Your ref: 24.0667  
Our ref: D3.24.0667  
Date: 5<sup>th</sup> September 2024

**App no: 24.0667**

**Address: Ground floor Unit 5b Abbey Works King Street Whalley**

**Proposal: Regularisation of unauthorised change of use to bar and music venue.**

Location Plan
Site Address: Salvage House, Unit 5b, Abbey Works, King Street, Whalley, BB7 9SP

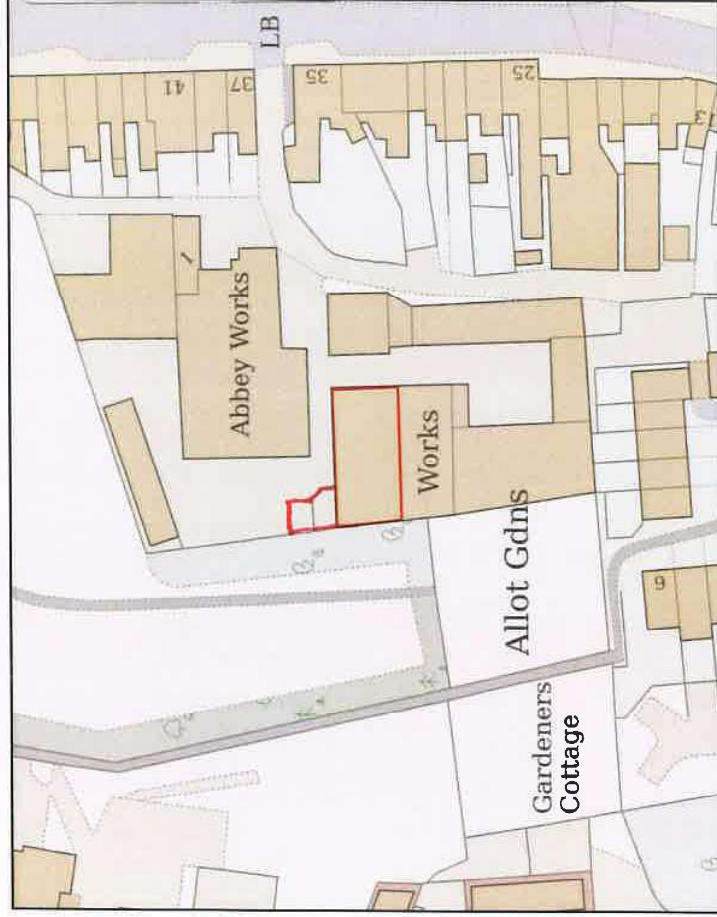
We would request that the access up to King Street and the car parking associated with the building is included in the red edge.
